PLANNING DEPARTMENT – Development Review Services

April 1, 2015

RE: **Winrock Town Center**
Drainage Master Plan (DMP)
Engineer's Stamp Date 2-5-2015 (File: J19D058)

Proj. file: 2031 SD BASIN 100-proposed.stm

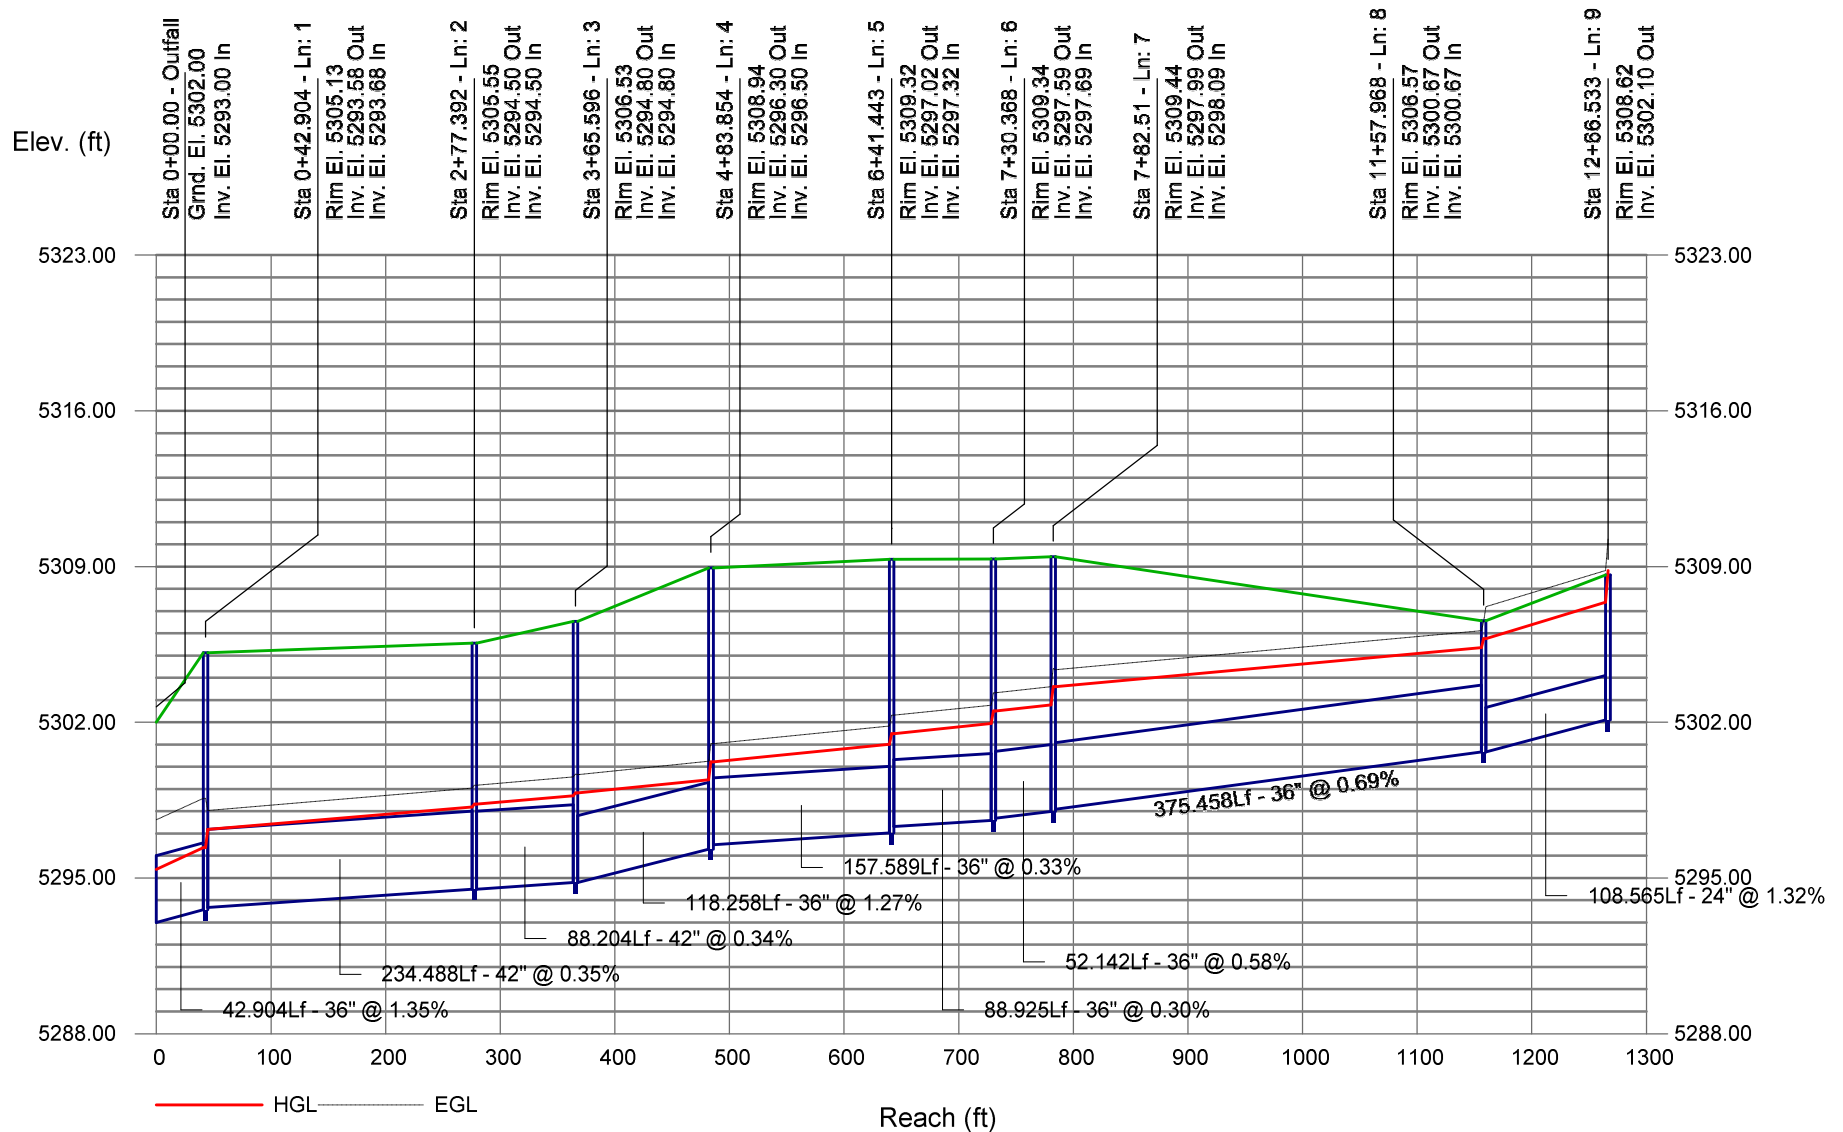
7. Provide a description of offsite basins, similar to the onsite basins.
 - a. Describe how Basin 101a discharges to the 36" SD. Was it thru an inlet or a rundown? Show inlet or rundown (indicate "existing inlet" with a note) on the Basin Map and a flow arrow.

- b. Describe how existing flows from Basin 151 cross Winrock Loop and are captured by inlets in the parking lot. A photo capture of this area would be helpful with flow arrows to describe existing flows. New storm drain thru Basin 510 and inlets will have to be constructed prior to any removals of the 24" SD system. State that 9.5 cfs is intended to be captured by the inlets at the access drive and discharge to Outfall #2 (42" SD). Show the proposed SD and the inlets on the plan (note the proposed inlets). State also that 18.0 cfs is intended to be captured by proposed inlets in Winrock Loop and discharge to Outfall #1 (again, show on plan and indicate "proposed inlets" with a note).

- c. Describe how Basin 101c is a pond that drains to an inlet and show inlet with a note and flow arrow on the Basin Map
 - d. Describe the flows from the DOT Park and Ride in the report as you noted in your response letter.

- c. Basin 530 may need to be revised to match Huitt-Zollars recent submittal.
- d. Describe how Basin 110 is being redirected to Outfall #1, and how future infrastructure will be needed. Show a proposed SD and inlets on the plan and indicate with notes.

WINROCK TOWN CENTER-BASIN 300

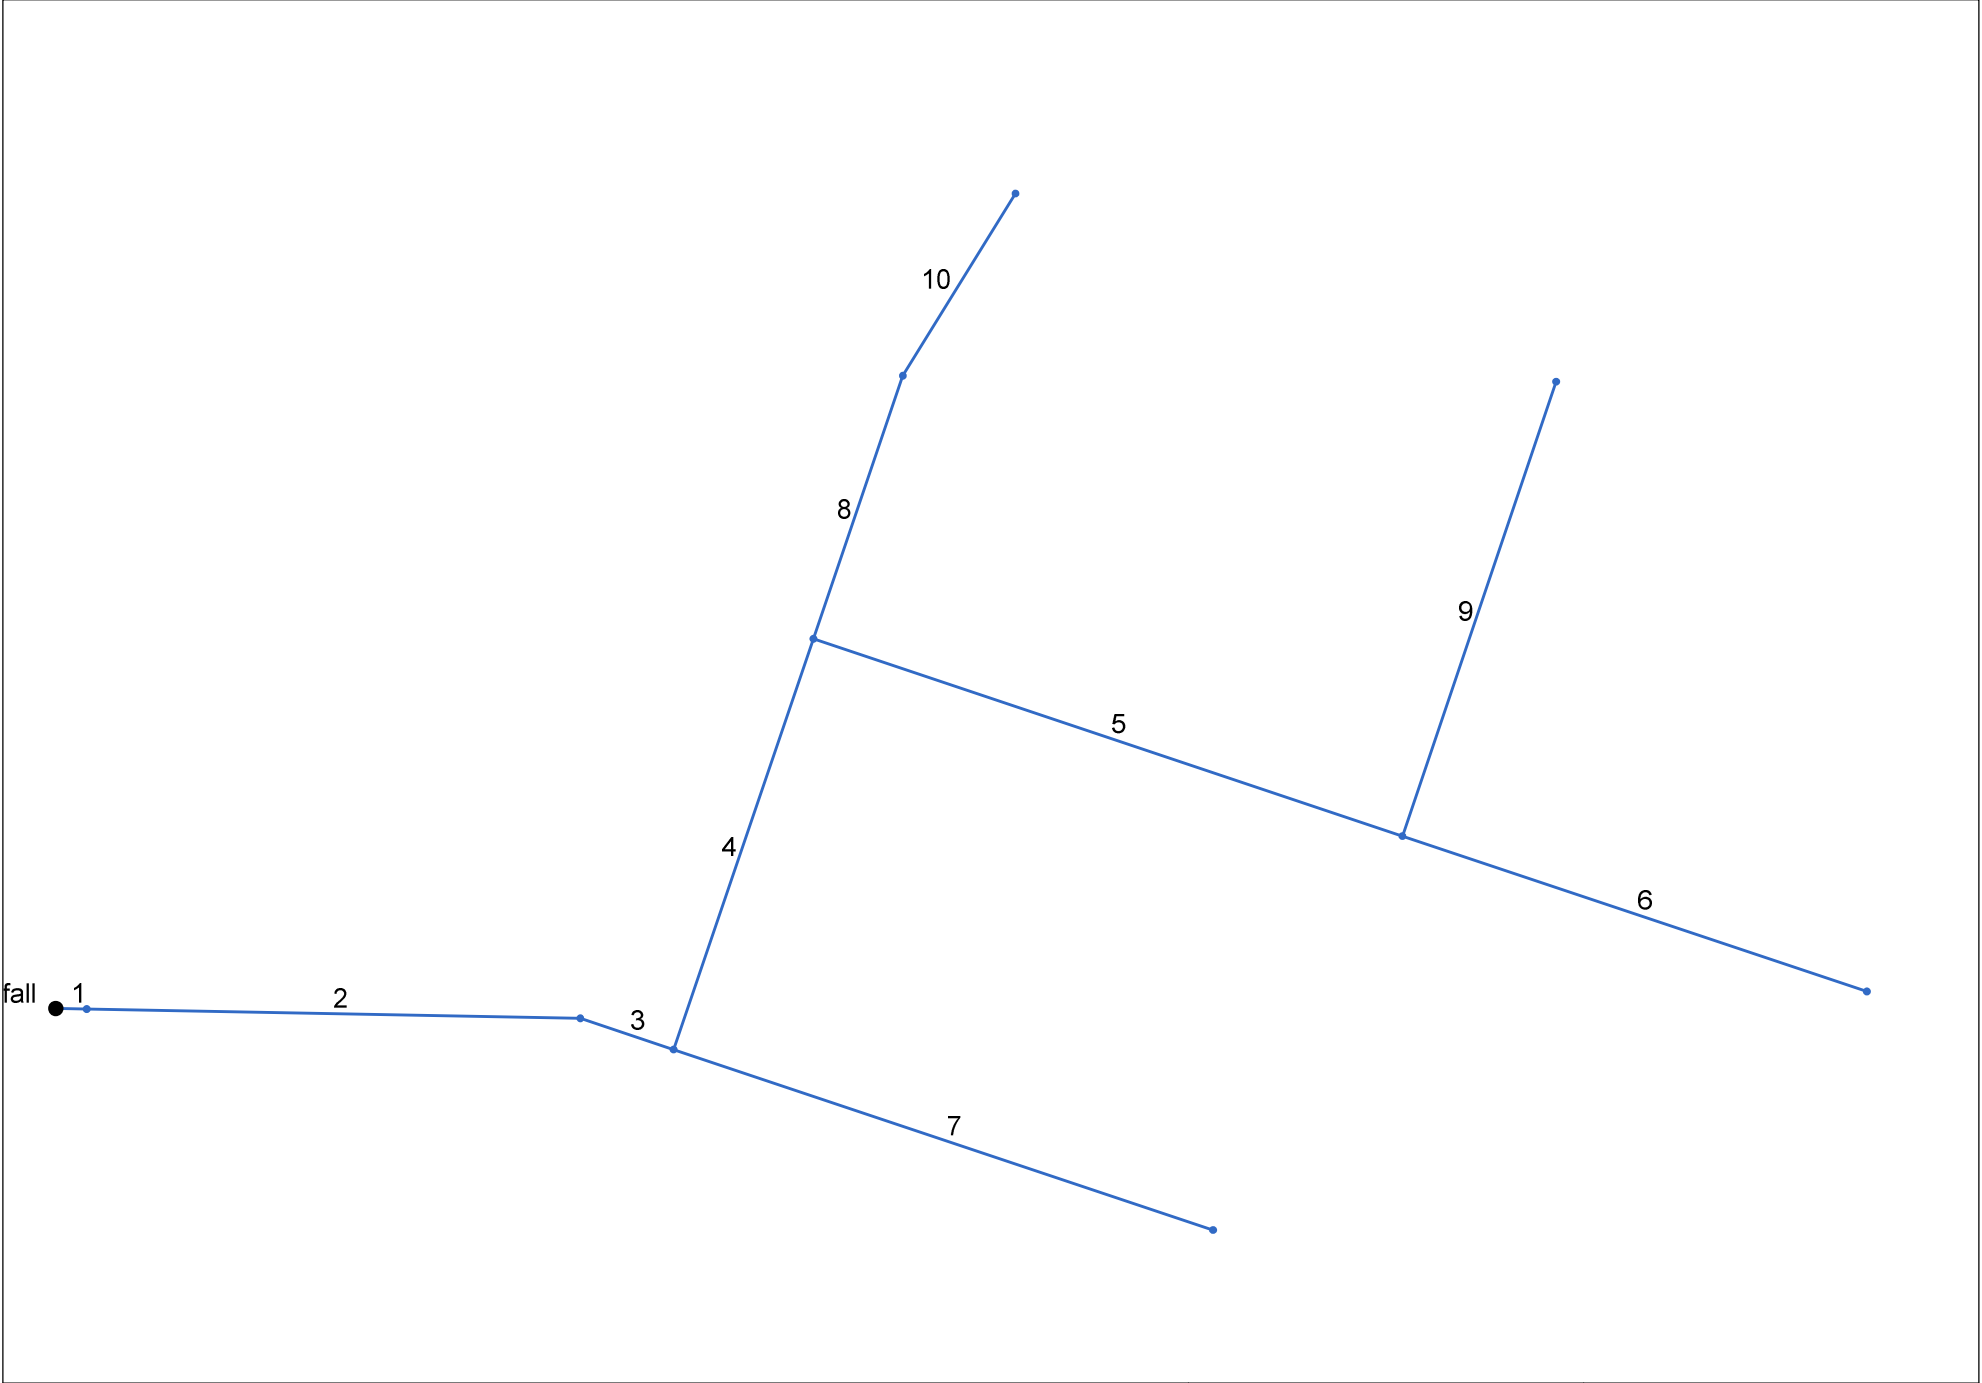
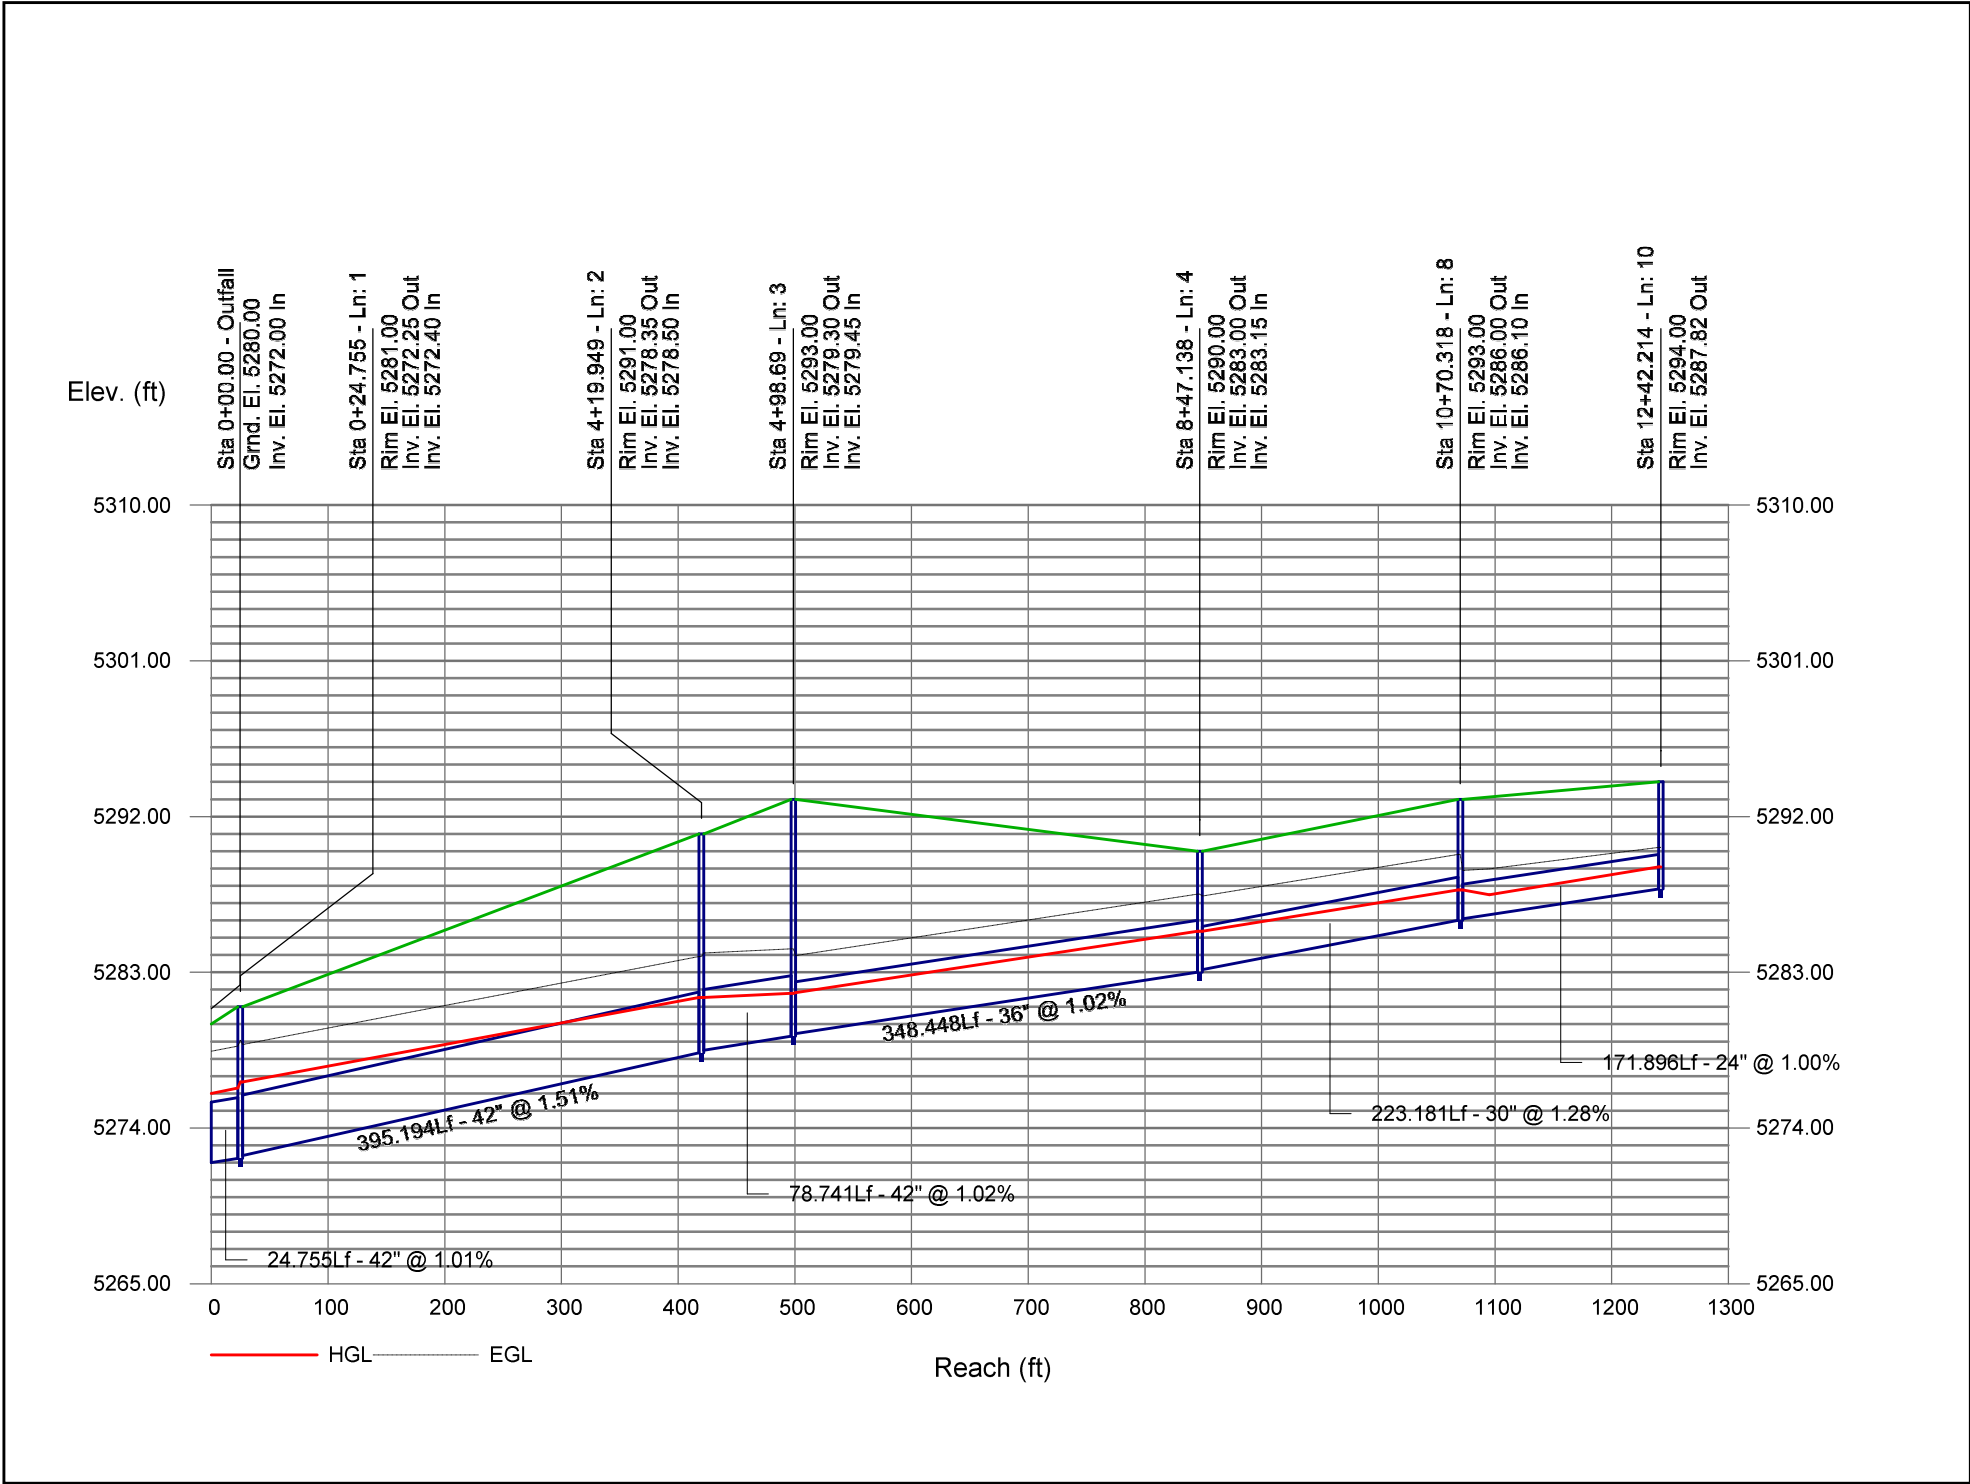
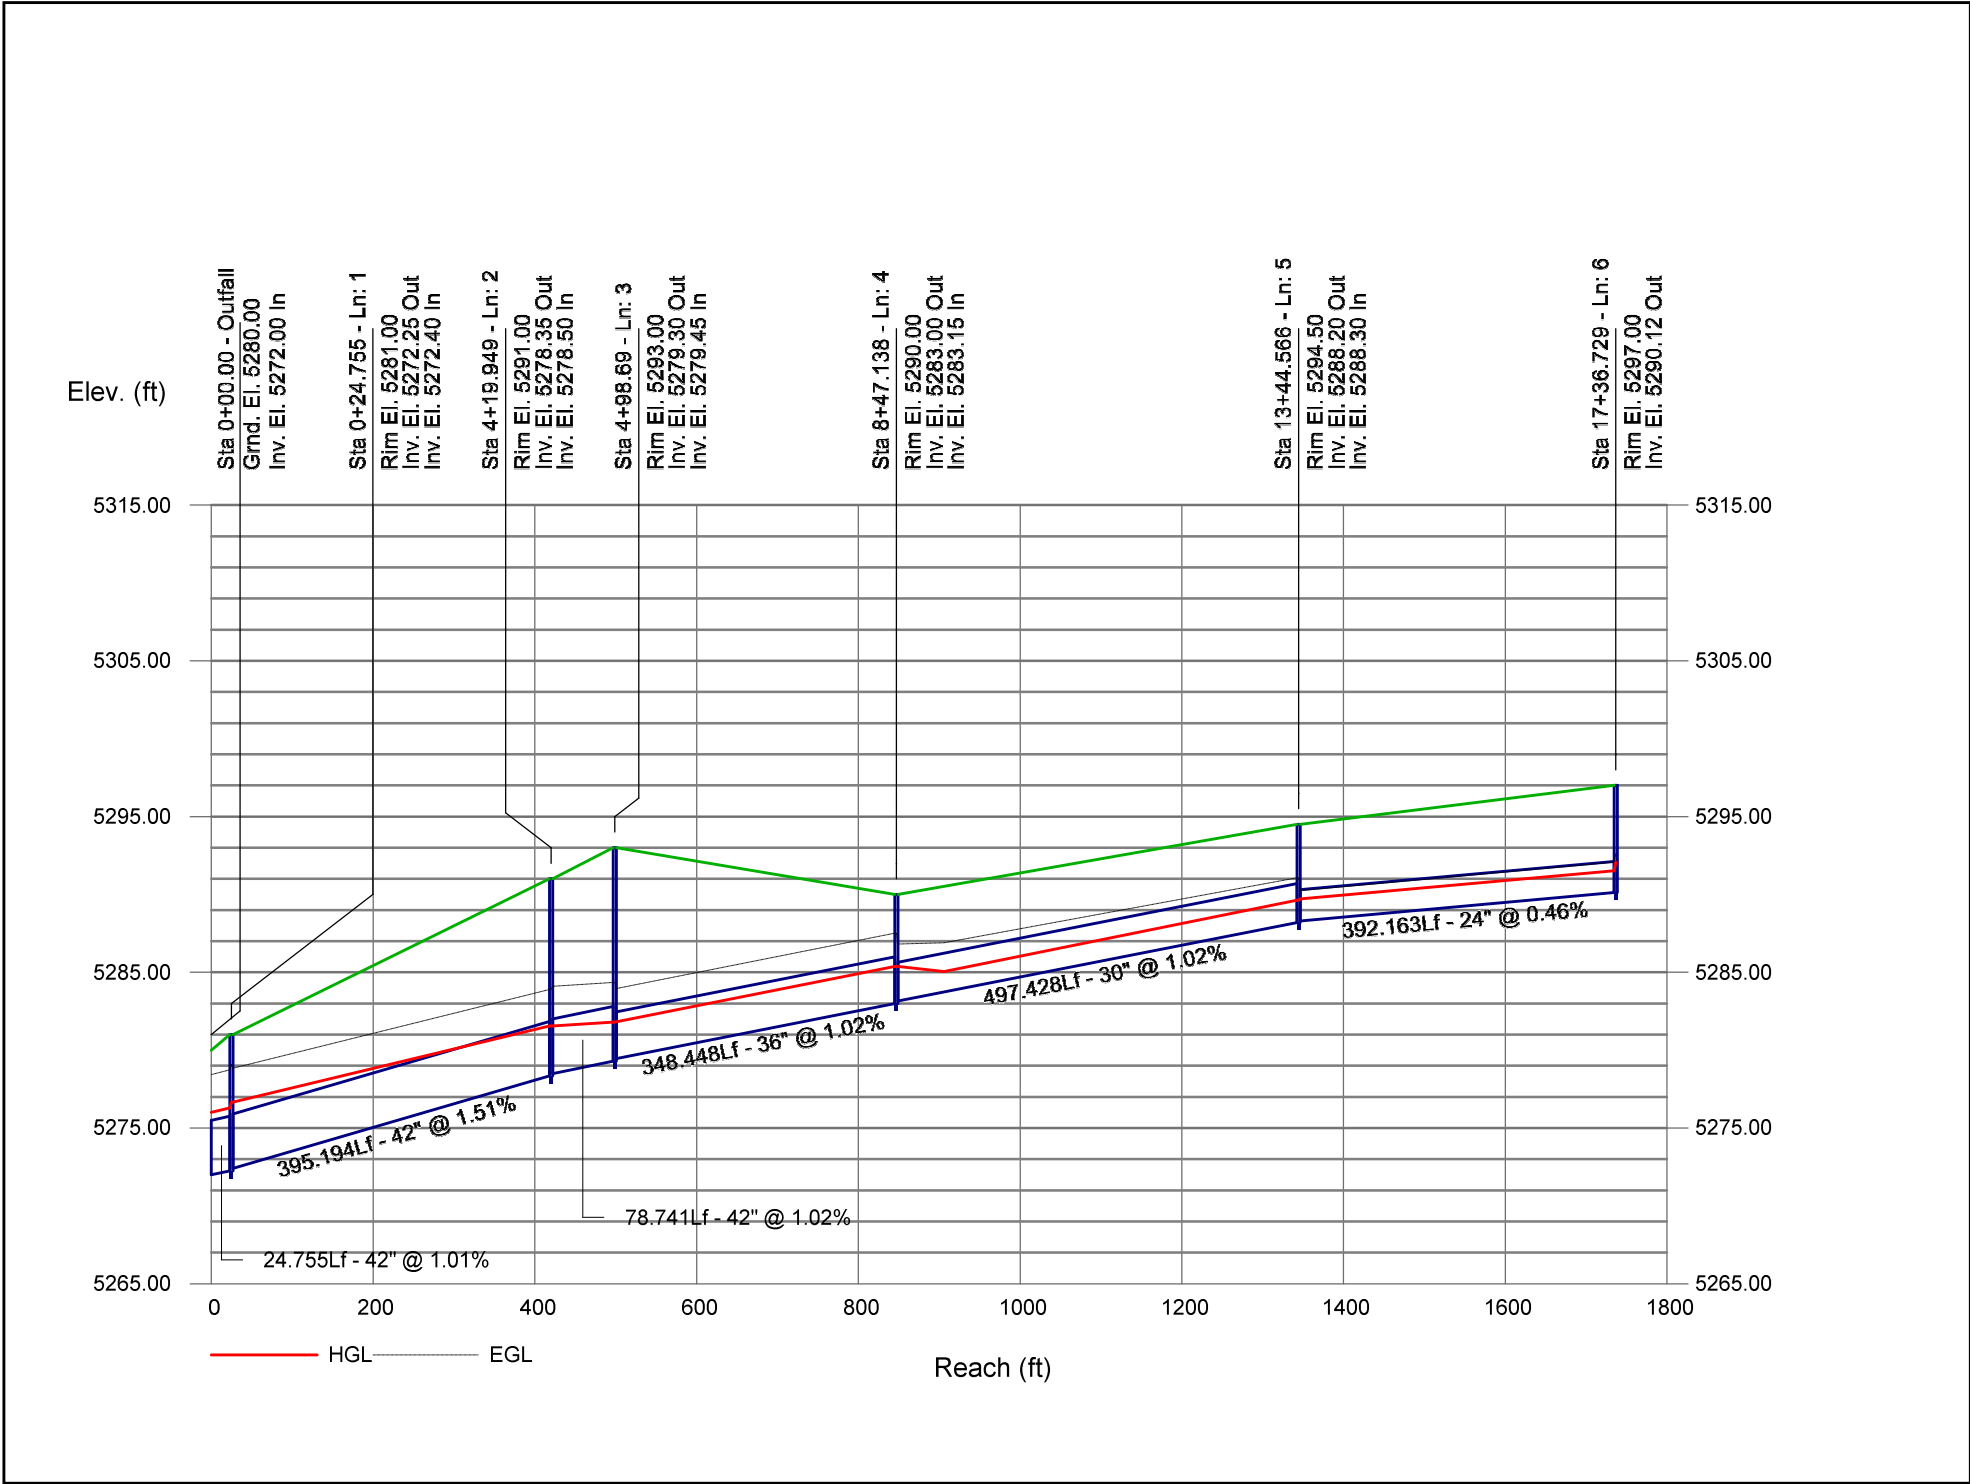
- e. Basin 400 discharges via surface flow to inlets on the ramp. Show inlets on plan and note as existing inlets. Show flow arrow to show that B400 does not discharge to the SD within its basin but is intended to maintain existing discharge.

- f. Show on the plan the size of Outfall #3 (discharge point outside of Basin 400)
- g. Huitt-Zollars Plan is utilizing existing SD in B400 that is not shown on DMP, and removing a SD that is shown in that same basin.
